**Project Name:** I-25 Tower Improvement

**Date Received:** 06/20/2017

**Jurisdiction:** El Paso County

TOWER ELEVATION

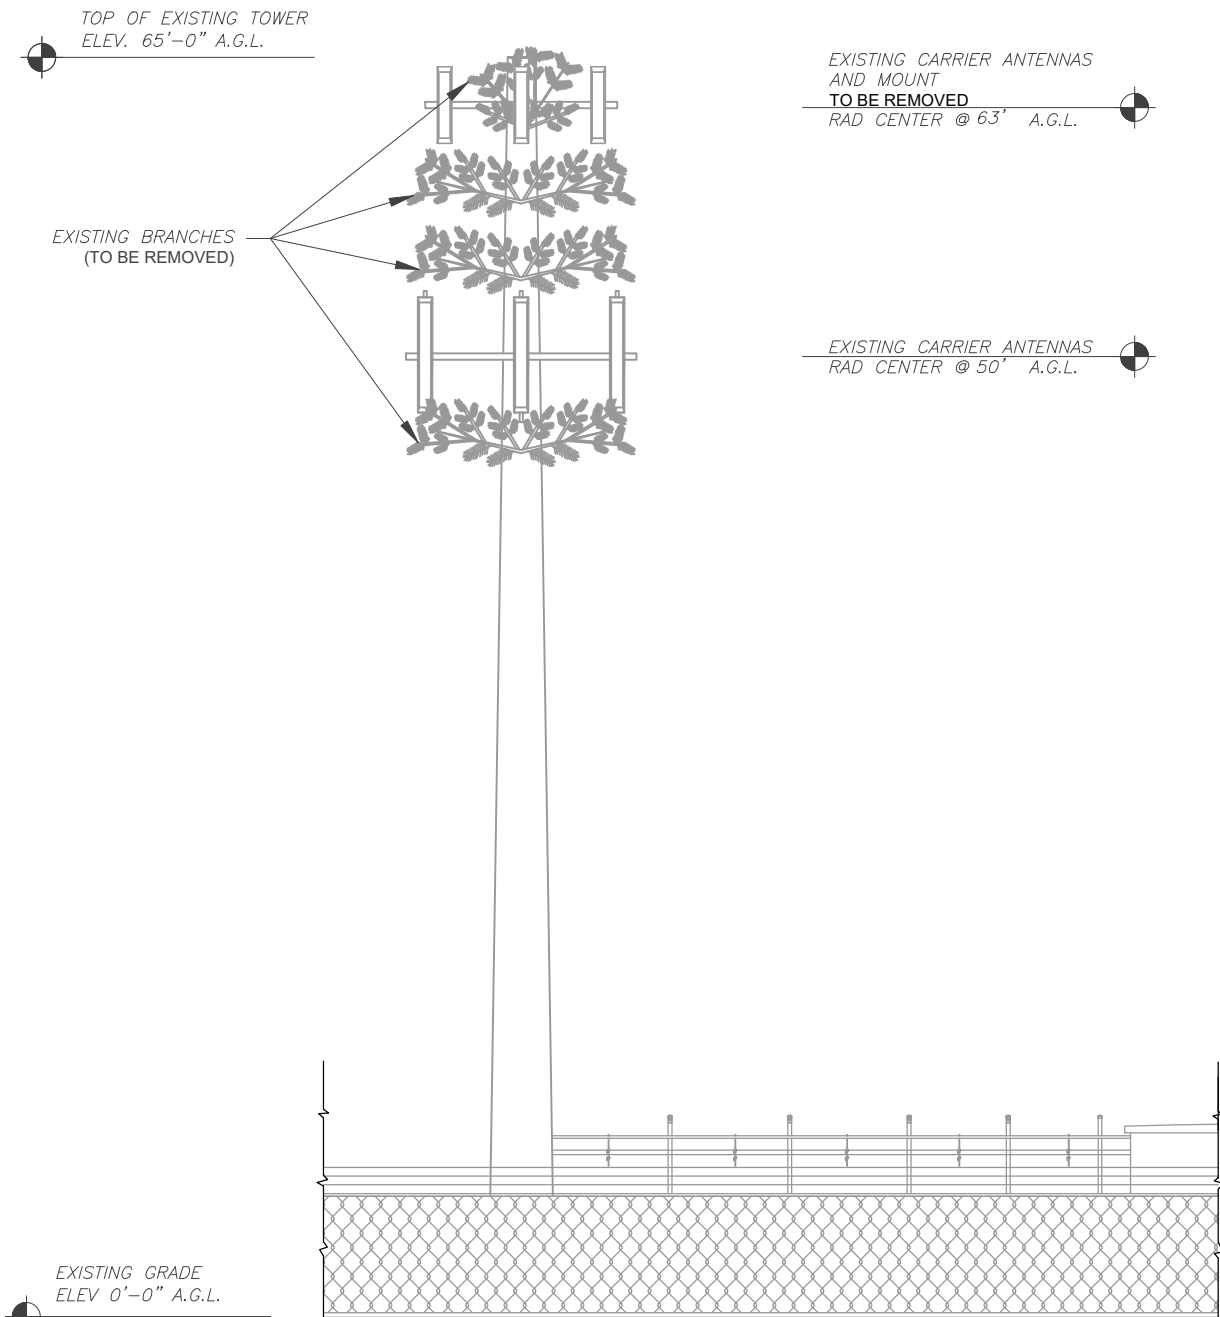
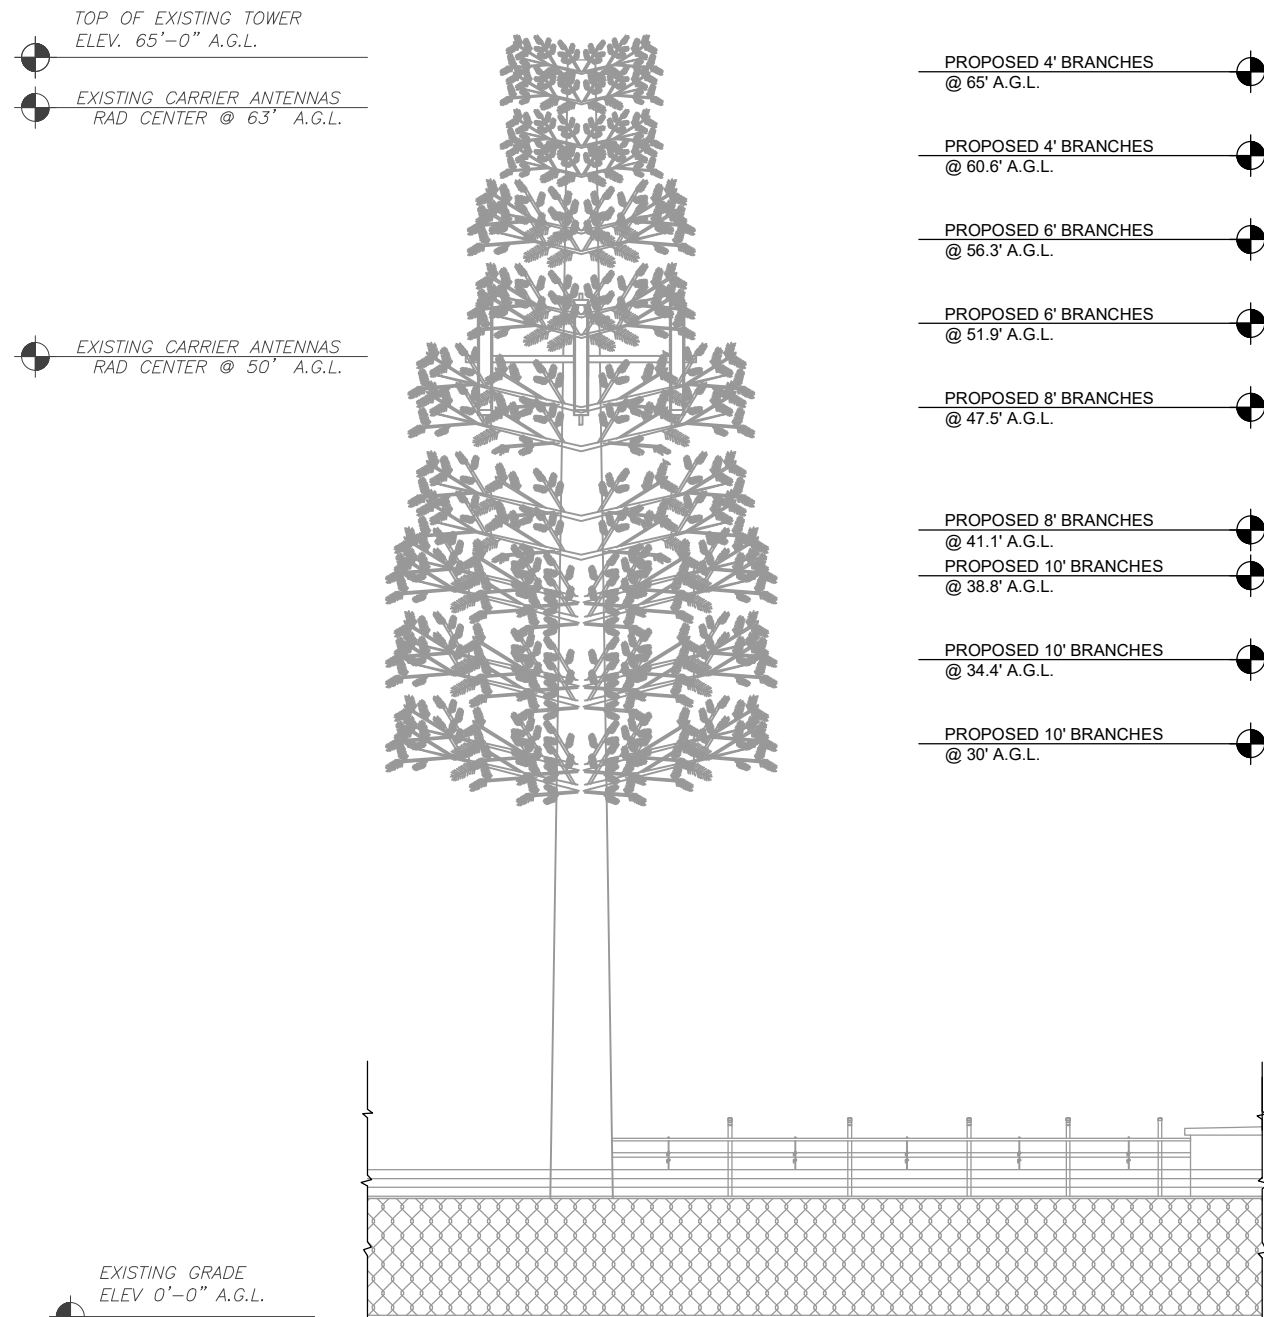
Douglas County Planning Services has reviewed the application and has the following comments. The modifications seem to improve the overall appearance of the existing cell site. The added branches create a stealth design which blend into the surrounding environment. My only comment would be to see if the applicant can extend the branches down further along the tree line.
